Application No: F/4/20/OUT
Site Address: Land at Ford Airfield Ford
Description of works: Outline planning application (with all matters reserved except for access) for the development of up to 1,500 dwellings (Use Class C3), 60-bed care home (Use Class C2), up to 9,000 sqm of employment floorspace (Use Classes B1), local centre of up to 2,350 sqm including up to 900 sqm retail / commercial (Use Classes A1-A5) and 1,450 sqm community / leisure floorspace (Use Classes D1-D2), land for a two-form entry primary school (Use Class D1), public open space, allotments, new sports pitches and associated facilities, drainage, parking and associated access, infrastructure, landscape, ancillary and site preparation works, including demolition of existing buildings and part removal of existing runway hardstanding. This application affects a Public Right of Way. This application is the subject of an Environmental Statement. This application may affect the setting of a Listed Building. This application falls within CIL Zone 1 - Zero Rated.

Thank you for your internet representation made on 13th March 2021 which has been recorded as an objection with the comments as follows:

FIGURE 12: ILLUSTRATIVE LANDSCAPE MASTERPLAN

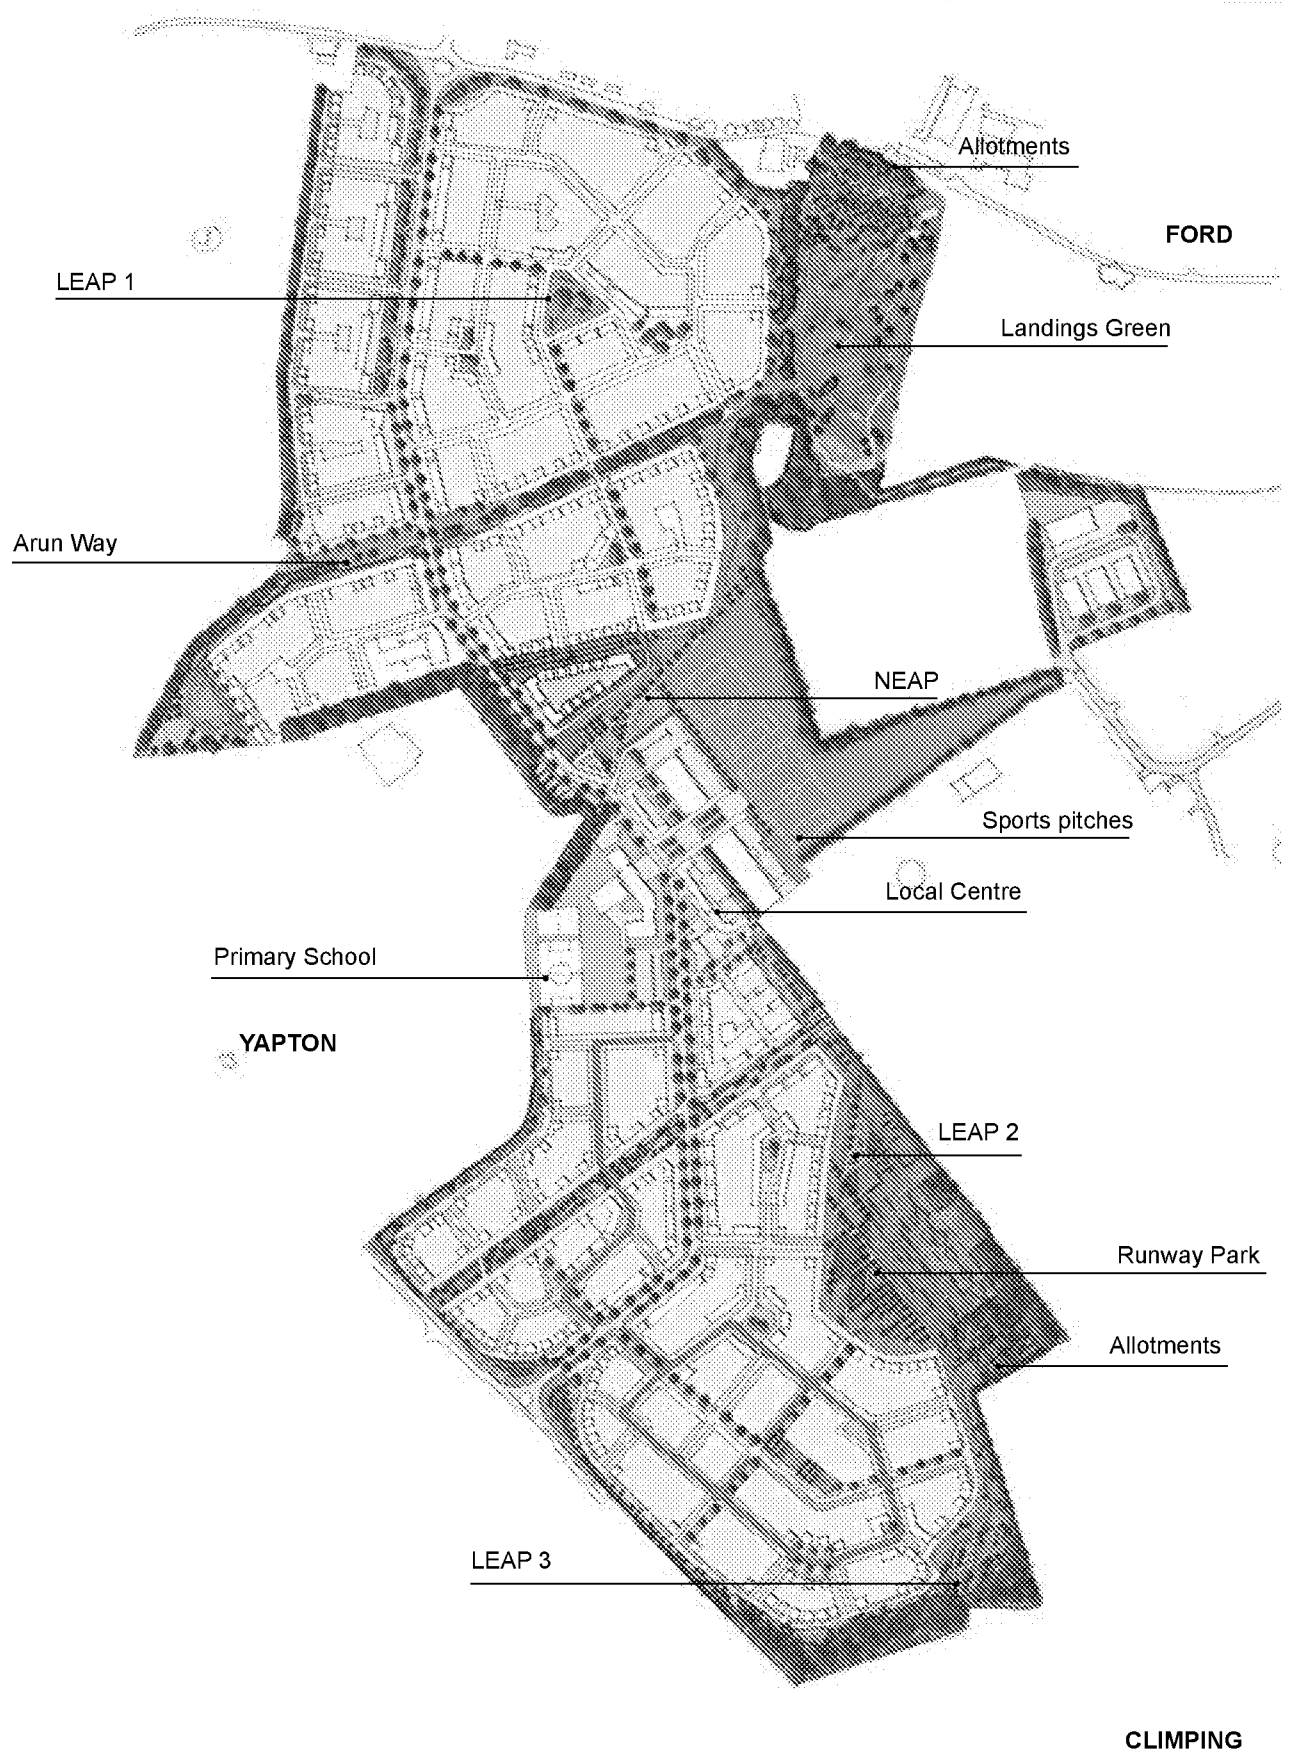
It is disappointing that the Masterplan's maps and text have omitted to refer as well to the line of the Canal to the east of the Grundon site towards Ford Road and the River Arun, which is still well within the development boundaries.

At the north-eastern corner, currently labelled "Formal Open Space", there is an opportunity to include a significant water feature to tangibly demonstrate the former canal heritage. This could include a rectangular pond simulating the dimensions of the old canal (c. 10m wide by say 50m long).

I suggest this proposal is included in outline now, in advance of the detailed design stage, rather than taking the current minimal approach such as placing a few information signboards, given such a strategic site and its

unusual opportunities.
